16 May 2022

Our Ref: R/2022/5
File No: 2022/275021
Your Ref: SSD-32489140

SSD 32489140 – Ascent Logistics Centre, Alexandria – Advice on EIS

Arboricultural Impact Assessment

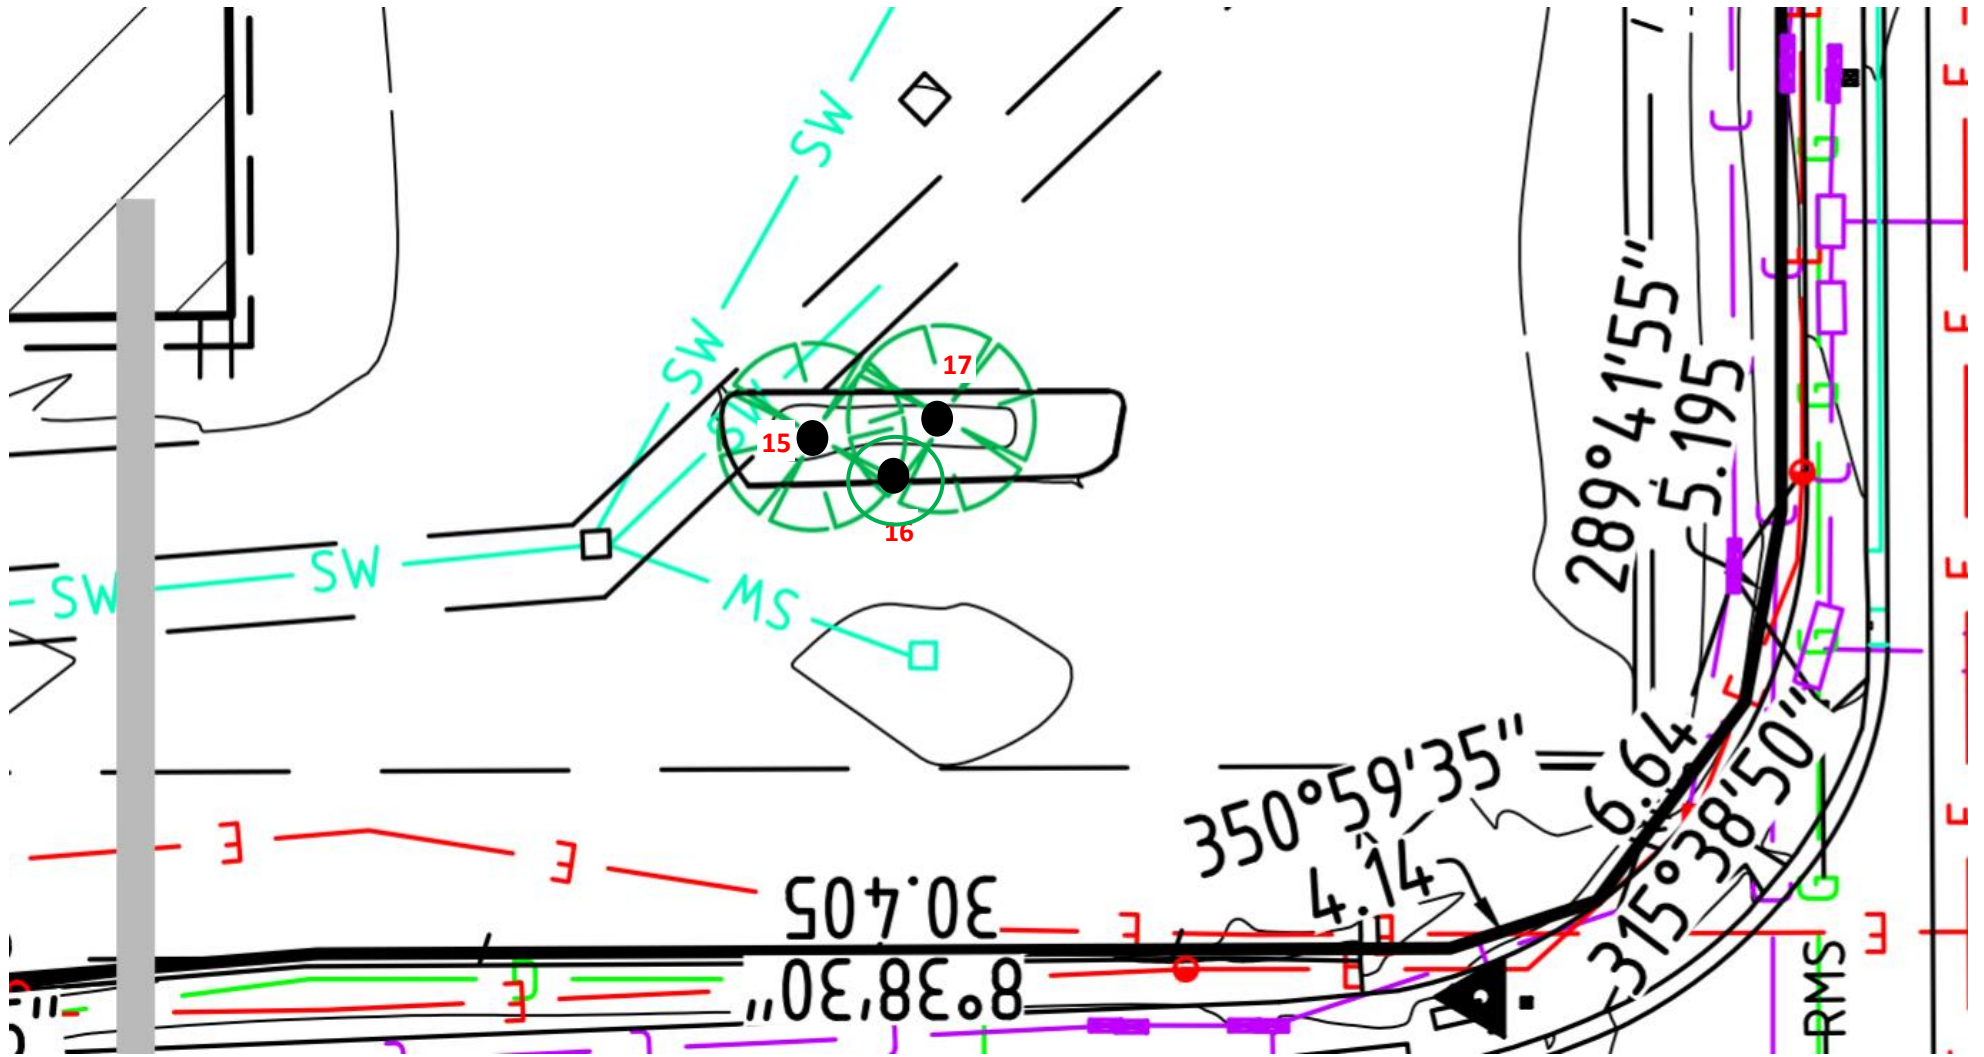
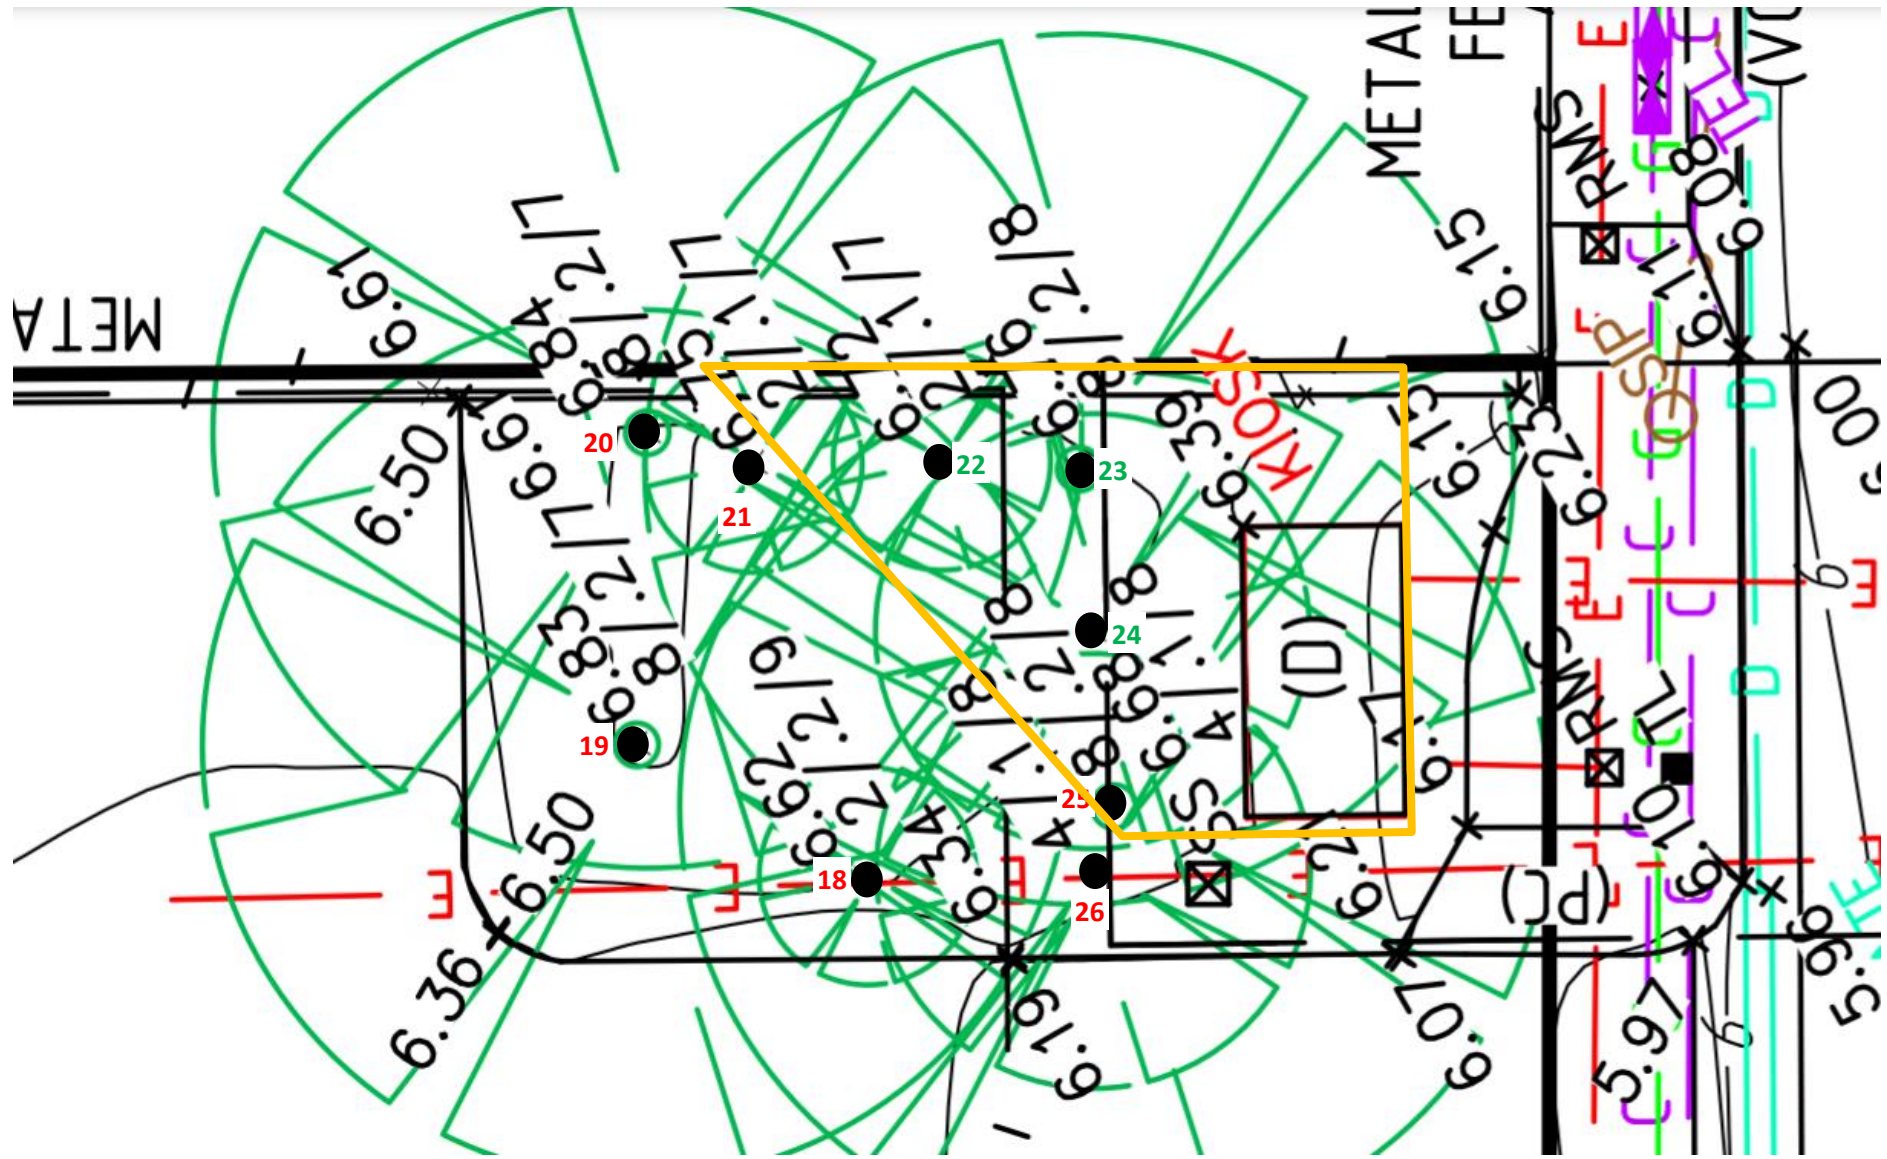
The City does not, however, support the removal of Trees 6 and 14. The plans indicate a new pedestrian footpath is proposed in the north-western corner. The alignment of the footpath necessitates the removal of Tree 6 which is rated high Landscape Significance and High Retention Value. Similarly, the plans indicate a new vehicle entry / exit point is proposed on the Bourke Road frontage. This is located adjacent to another entry/exit point located further south. The proposed driveway alignment necessitates the removal of Tree 14 which is rated high Landscape Significance and High Retention Value.

The removal of high Retention Value trees should be avoided wherever possible. New designs should accommodate and retain high valued trees unless they are substantially restricting any development from occurring. This is not the case at this site as the trees are located close to the property boundary.

High Retention Valued trees are considered important and should be retained and protected. Design modification should be considered to accommodate the Tree Protection Zone (TPZ) setbacks as prescribed by the *Australian Standard AS4970 Protection of trees on development sites*.

SETBACK DIAGRAM

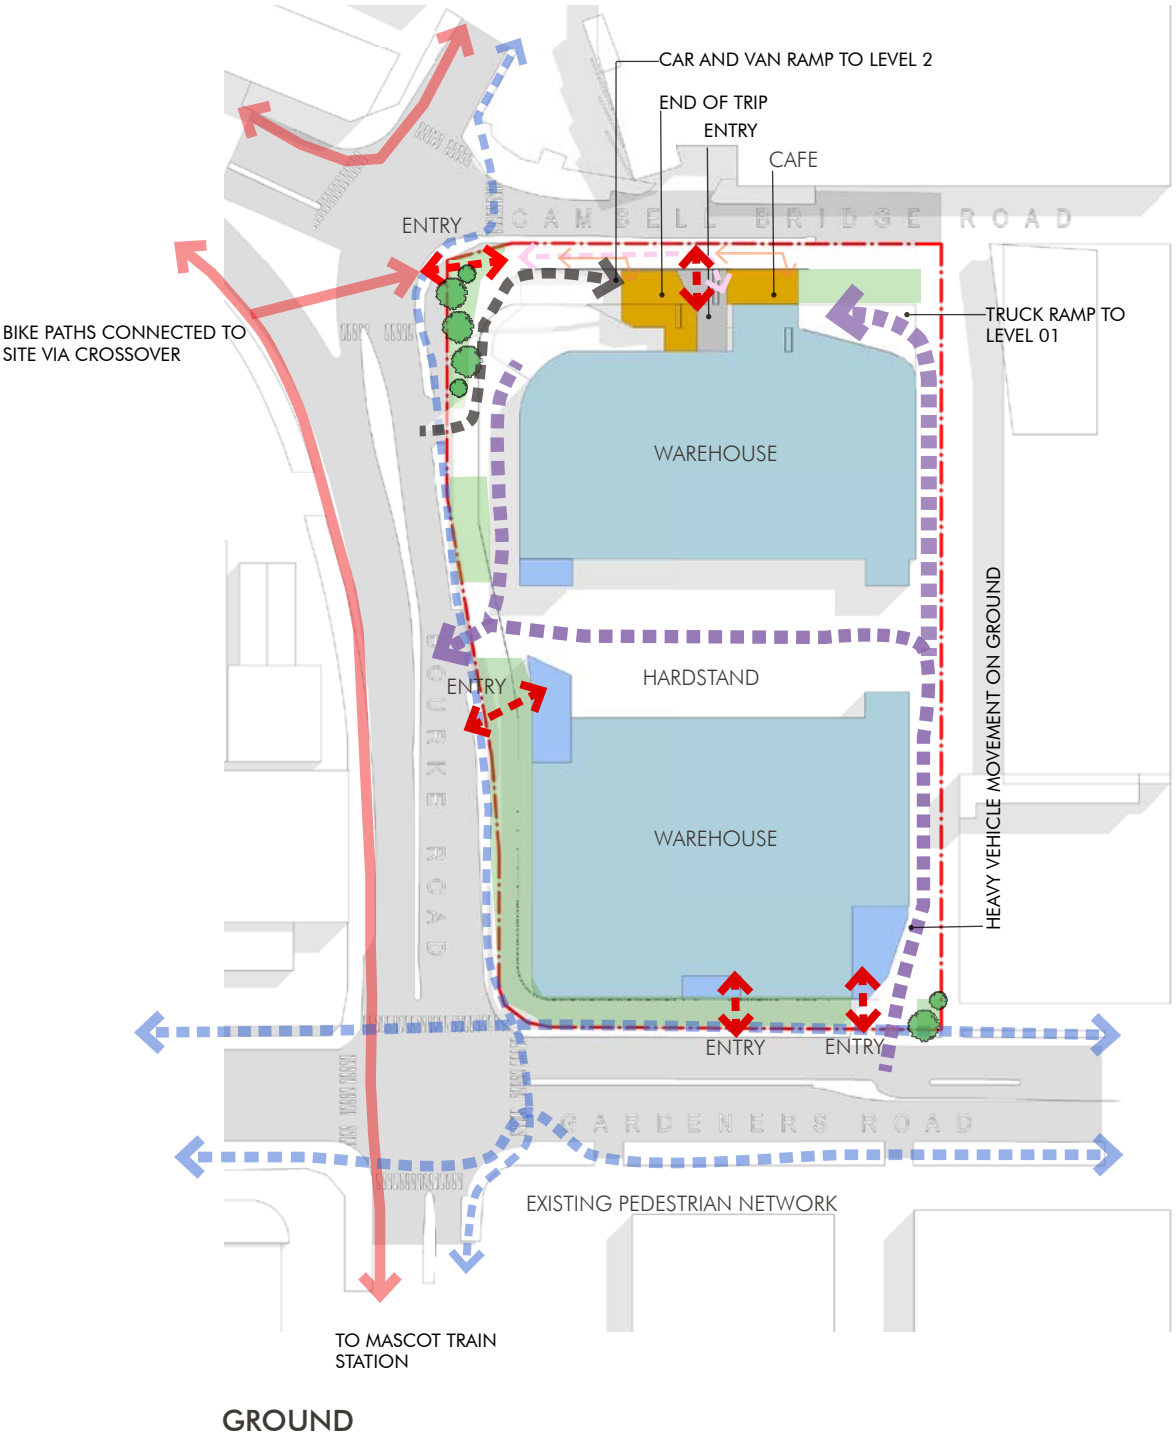
The proposed building does not present a high-quality frontage and does not comply with the building envelope and 6m setback to Bourke Road as required by the SDCP.

The City notes the modelling of the facade increases the visual dominance of the reduced setback and the intrusion of the building into the street setback may have an impact on planting.

It is recommended that building massing be rationalised and be located within the site respecting a clear 6m setback to Bourke Road open to the sky with no upper level encroachments.

DEEP SOIL 1644.75 m²
PERMIABLE 1356.61 m²
TOTAL AREA OF DEEP SOIL 3001.36 m²

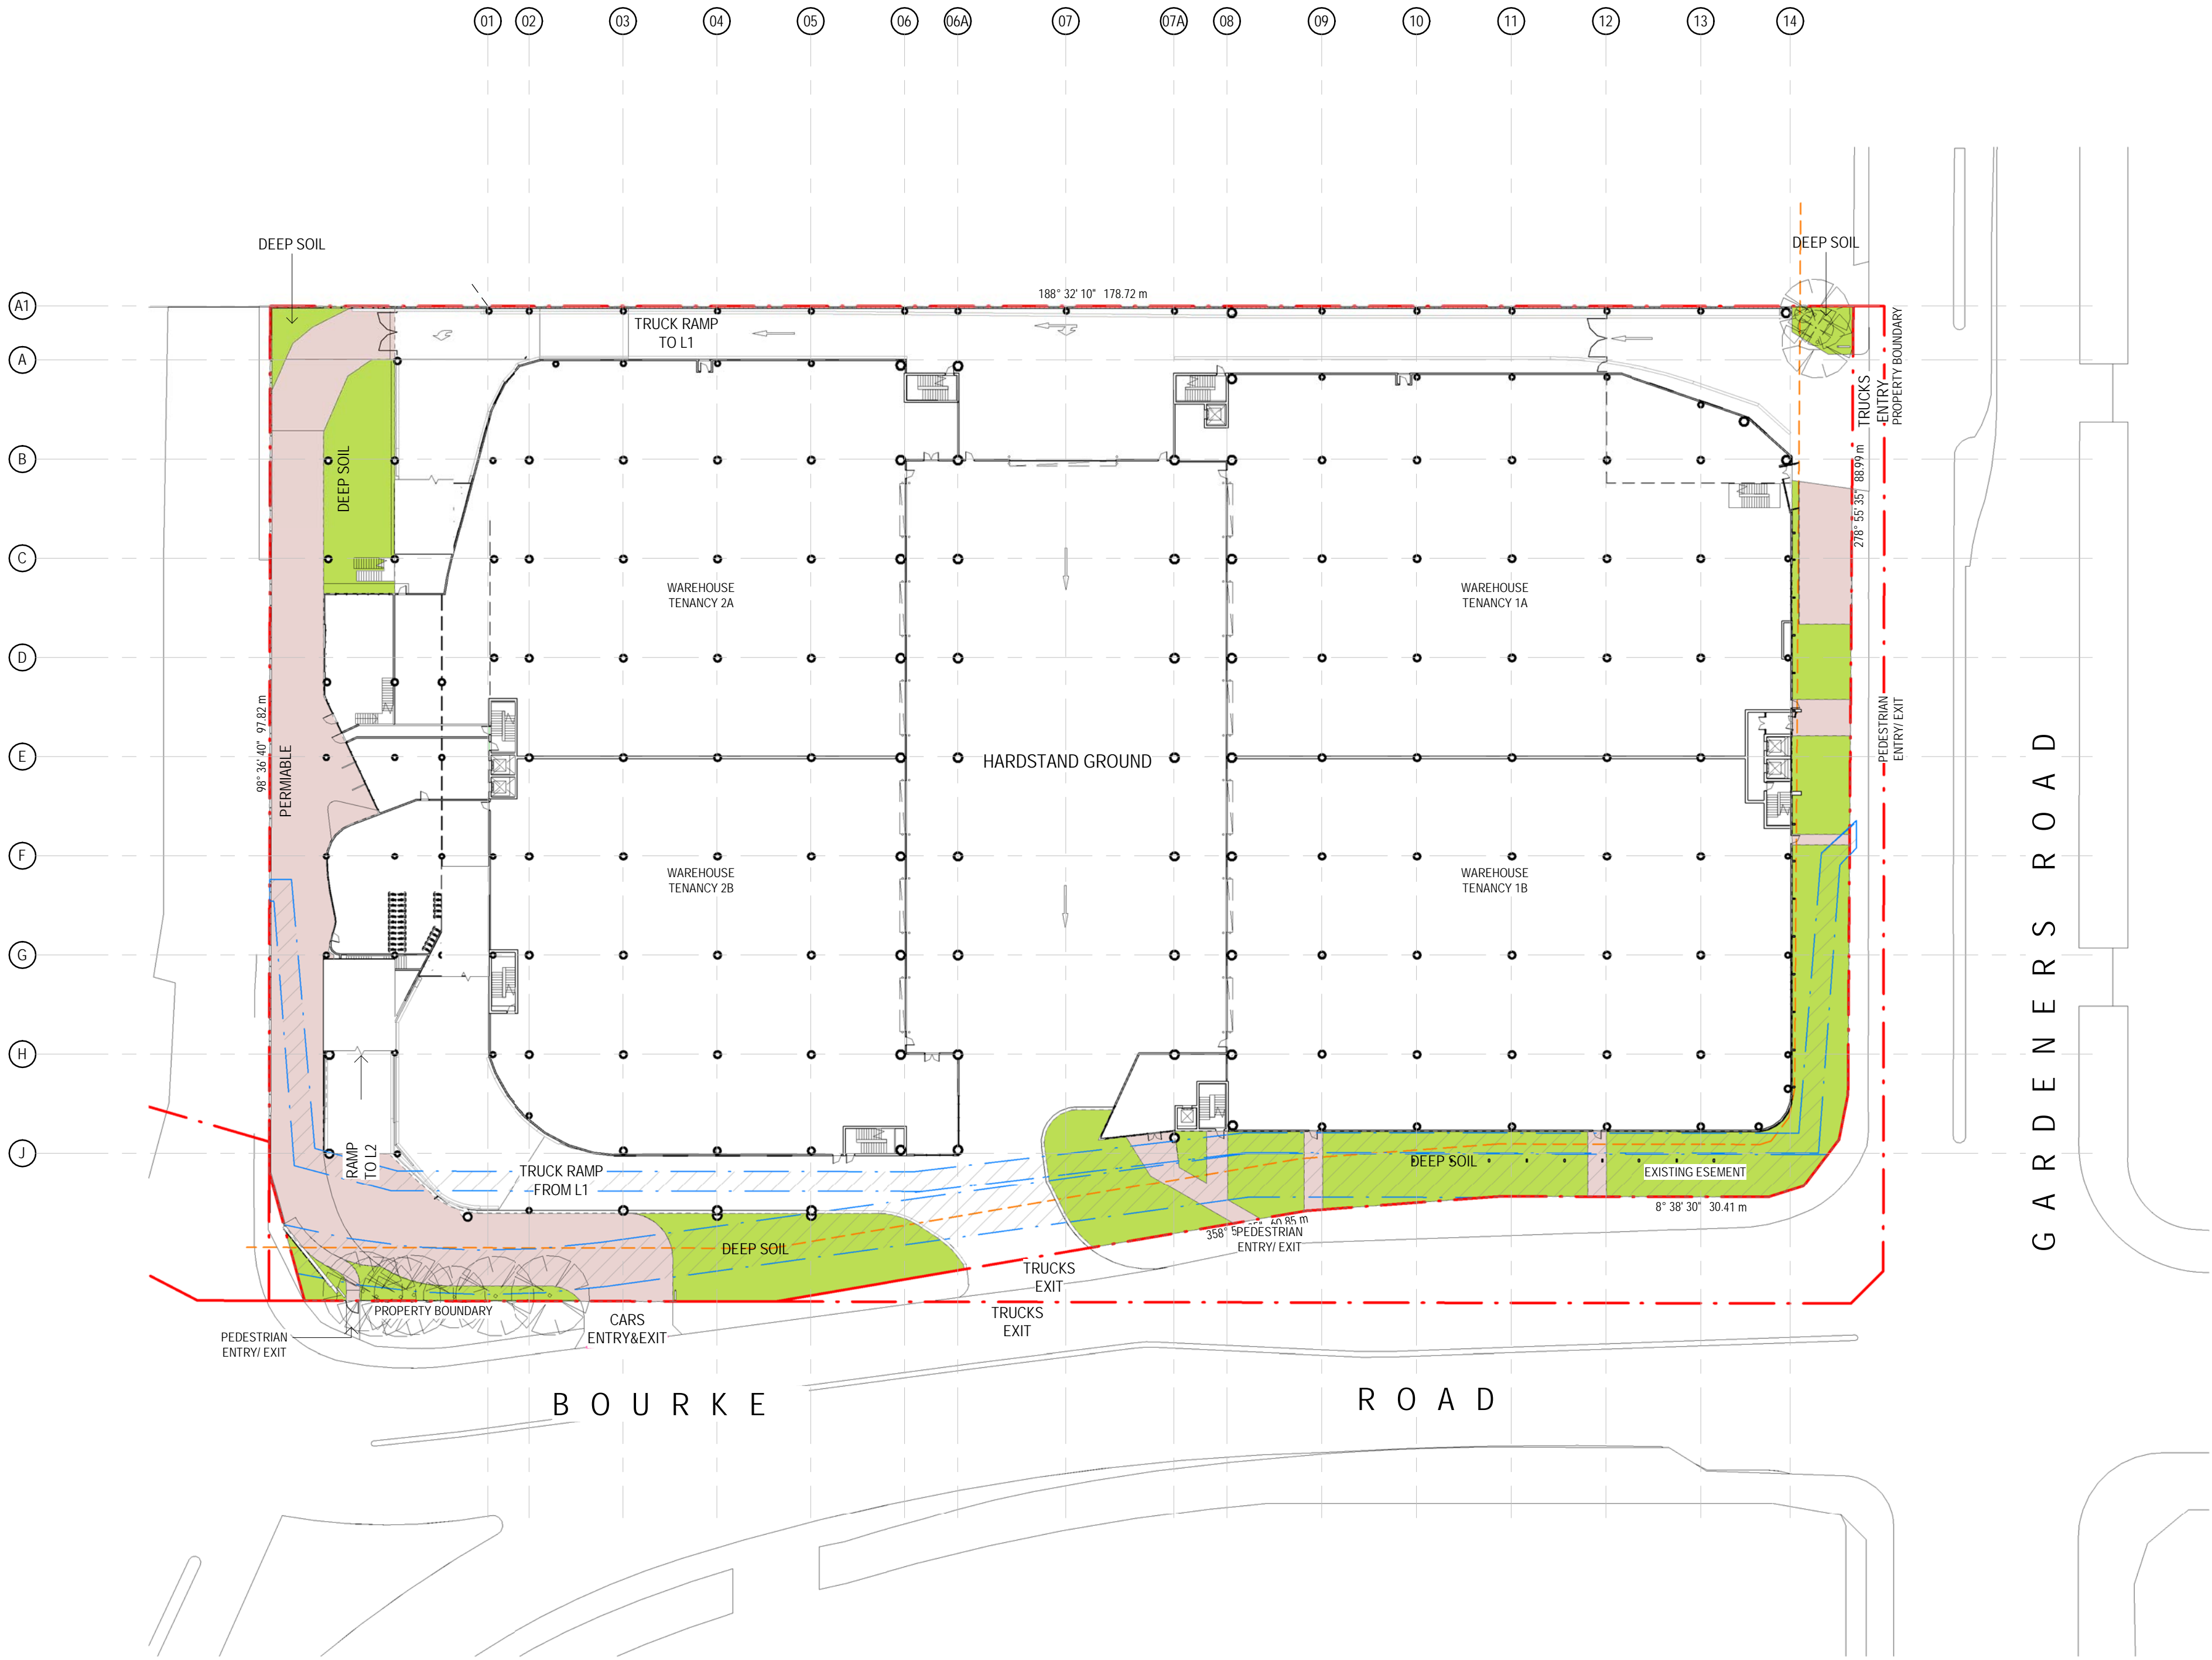
The City notes that the provision of deep soil within the site appears to be miscalculated. There is a large portion to the north-east corner of the site that is overhung by the ramp leading up to the car park, and accordingly is not considered deep soil. Secondly, almost half of what is proposed is permeable paving that is not adjacent to unencumbered deep soil, nor does it support any tree planting. The building envelope should be modified to have less site coverage and provide at least 15% canopy coverage in true deep soil in addition to contributing further to site greening and canopy coverage.
